2024/0548

113 High Street, Dodworth, Barnsley, S75 3RQ

**Formation of extension to an already established dropped kerb and new vehicular driveway.**

PROPOSED SITE PLAN
SCALE 1/100

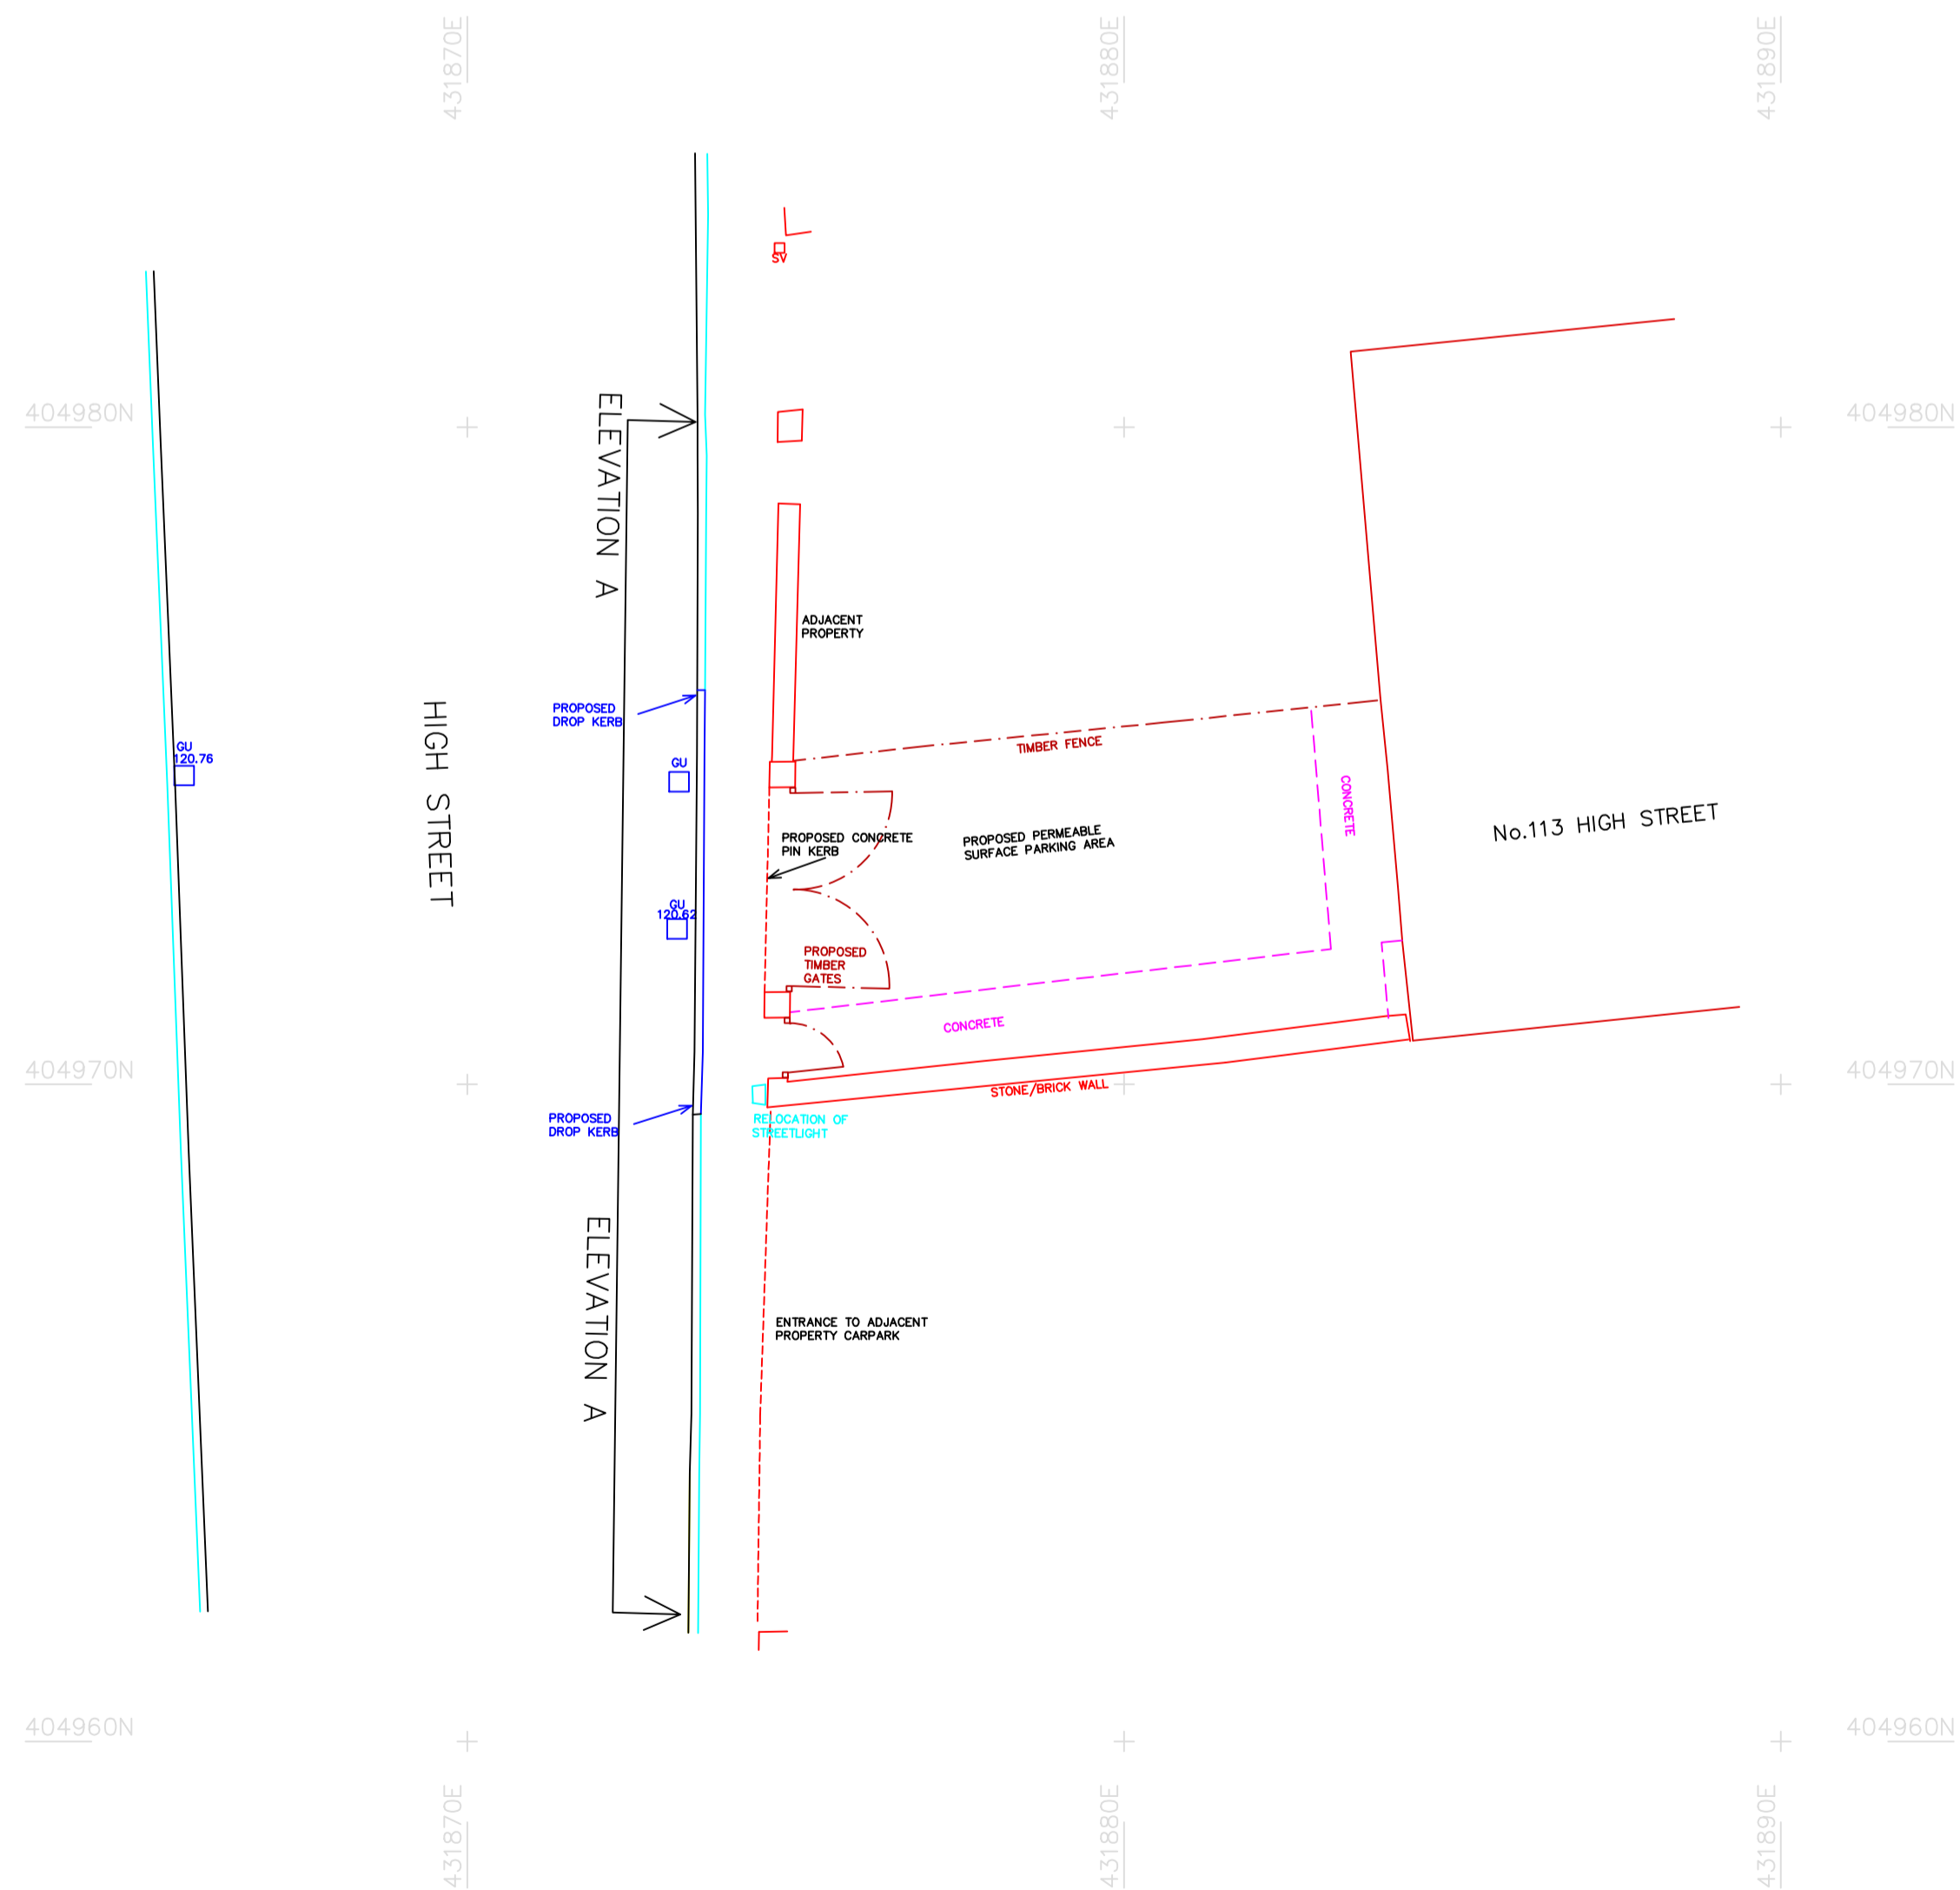
*“One of the primary requirements for a new vehicular access from a classified road is that the site must provide adequate space within its boundaries to allow vehicles to turn and both enter and exit in a forward direction. Unfortunately, the proposed layout does not meet this criterion. In addition, where gated access is proposed, it must be positioned a minimum of 5 meters from the edge of the carriageway to prevent obstruction of the highway. The proposed placement does not meet this standard, potentially causing hazards for both vehicles and pedestrians.*

*“Furthermore, there appears to be a demand for on-street parking in the vicinity. While off-street parking may be acceptable in some comparable locations, in this case, the proposed access could negatively impact the availability of existing on-street parking. The alignment of High Street, combined with the potential presence of on-street parking, may also create visibility concerns for vehicles exiting the proposed driveway.*

*“In this instance, I am of the opinion that the introduction of a driveway at this particular location would have safety implications in terms of possible visibility constraints and difficulty exiting the driveway should vehicles be parked opposite the access.”*

Having considered the proposal, including ongoing communications during the application process, the LPA empathises with the applicants' rationale for the proposed development. However, personal circumstances cannot be taken into account as they are not a material planning consideration. The LPA generally agrees with the comments made by Highways Development Control and shares their concerns in relation to the lack of turning space and potentially limited visibility due to the alignment of the highway, especially to the north where the highway becomes elevated and curves. Visibility to the south is not likely to be as limited because of the straighter alignment of the road. However, vehicles travelling northbound could pose a risk as drivers manoeuvre over the central road markings to pass parked vehicles on the west side of the highway. This could prove to be unsafe should the applicants' vehicle egress the application site in a reverse gear. The parked vehicles themselves could pose further issues with limited space to effectively and safely manoeuvre and egress the site. The identified highway safety concerns weigh significantly against the proposal.
